Reference: 1020168 L07G 884-928 Mamre Road Kemps Creek ENV CNVMP DPIE questions.doc

RE: 884-928 Mamre Road, Kemps Creek Response to DPIE comments

Acoustic Works (AW) was engaged by Altis Property Partners to prepare an environmental noise assessment for a proposed industrial estate to be located at 884-928 Mamre Road, Kemps Creek.

Figure 10: $L_{Aeq,15min}$ noise contours (Day)

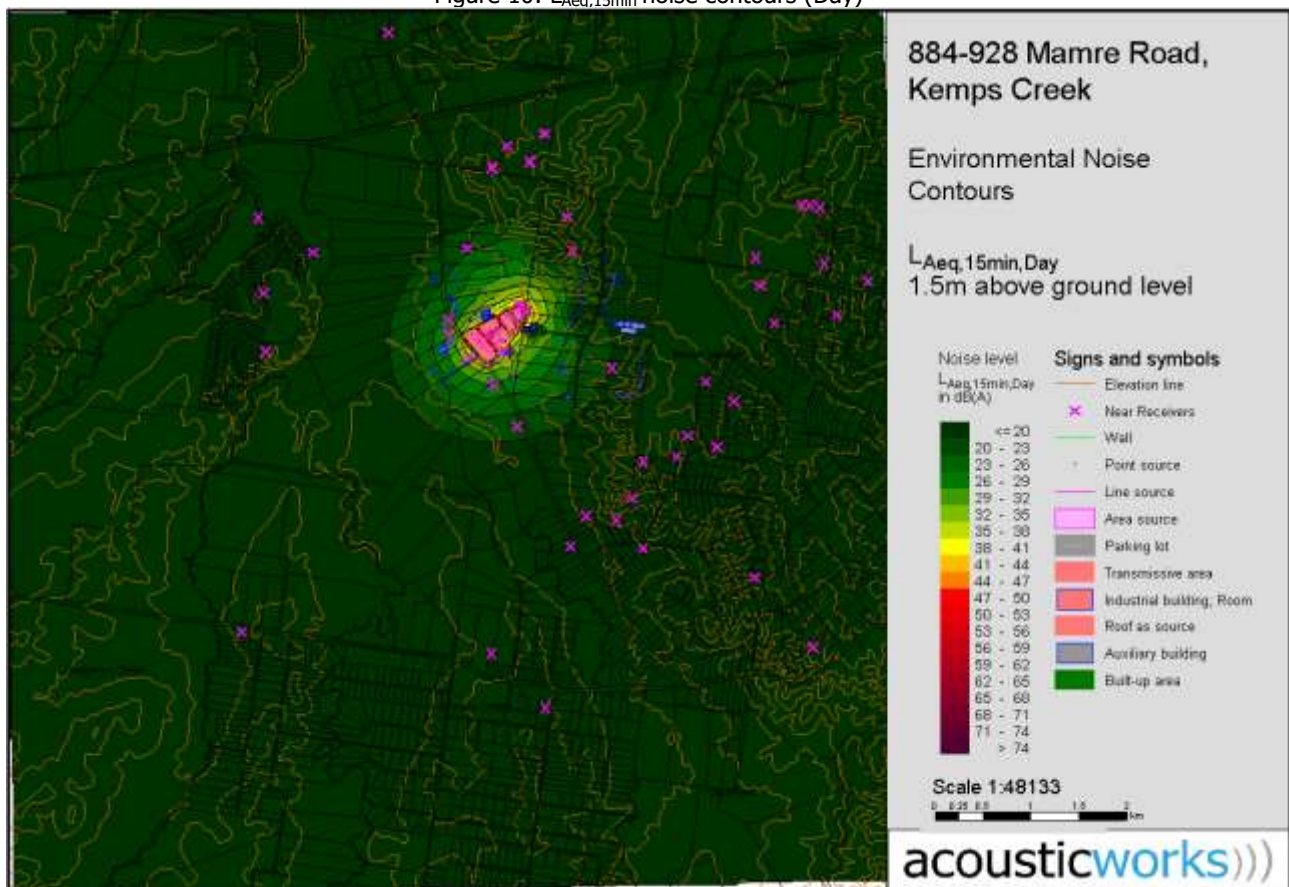
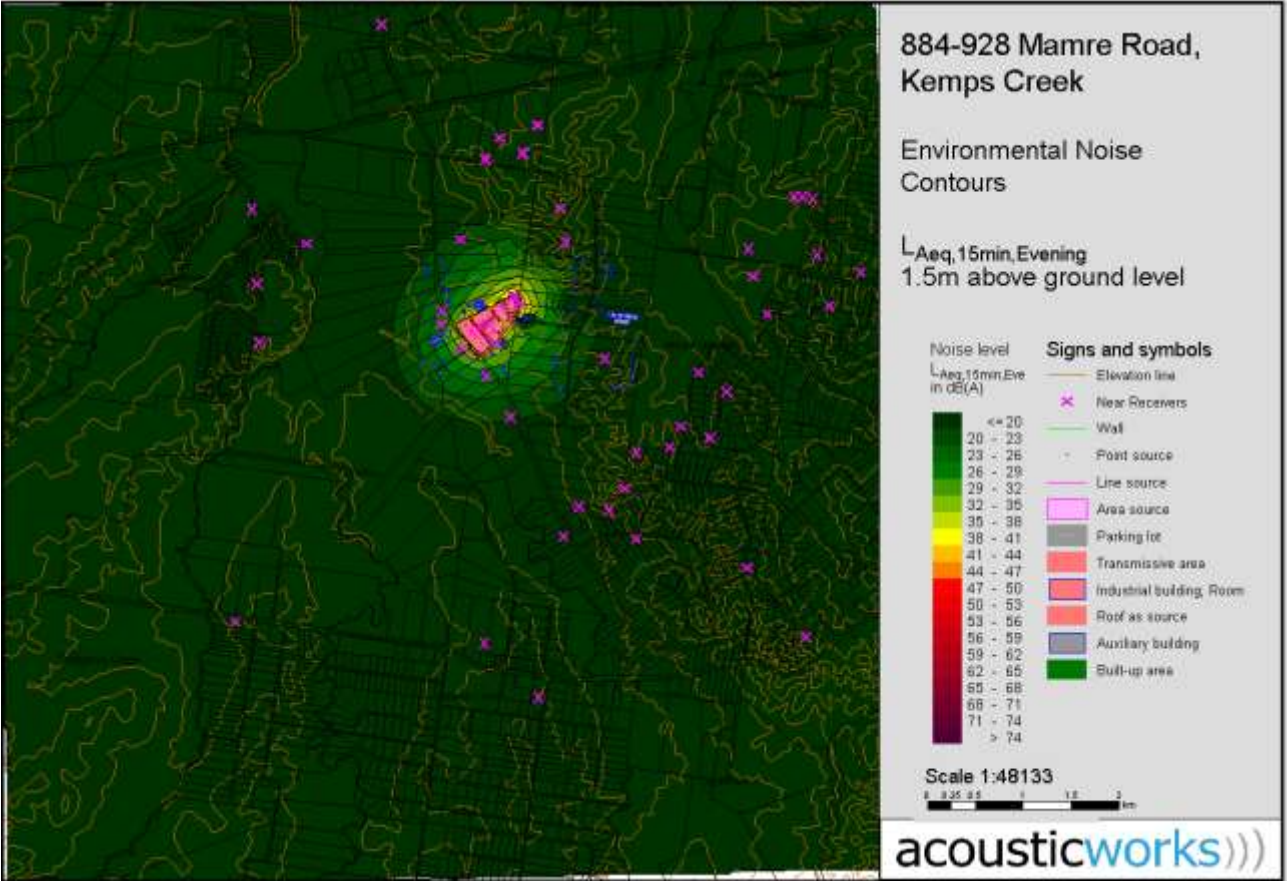
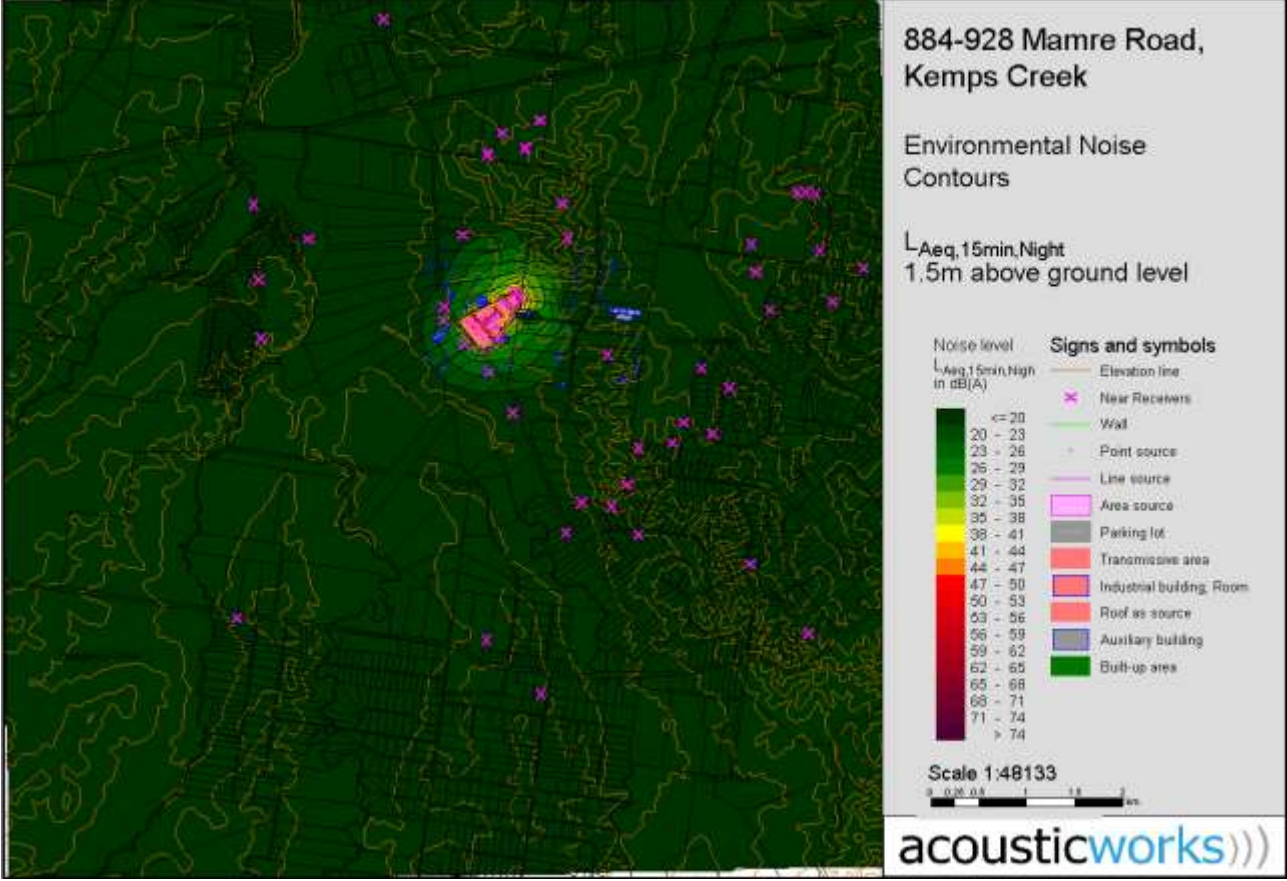
No.	DPIE Comment	Acoustic Works Response
		A contingency strategy to account for prospective tenants planning to undertake activities outside the scope of this assessment has been added to the updated report in Section 12.7.
3	<i>Operational noise that could potentially escape of the warehouse building envelope need to be assessed i.e. opening of loading docks</i>	Operational noise that could potentially escape the warehouse building envelope was included in the assessment. To clarify this, Section 8.1.1 has been updated and an addendum to this letter (high resolution contour map) provided to demonstrate to the department the effect of internal warehouse noise emanating from open warehouse doors.
Cumulative noise impacts at sensitive receivers		
4	<i>The Applicant is to:</i> <i>include additional sensitive receiver locations outside the MRP as detailed in the attachment and the BAPS Temple provide predicted operational noise levels at these additional receiver locations and update the remainder of the report as required</i>	Additional receivers requested by DPIE (29 in total) are now included in assessment and the report has been updated accordingly. Refer to Section 5.3, Table 24 and Figures 10 to 12.
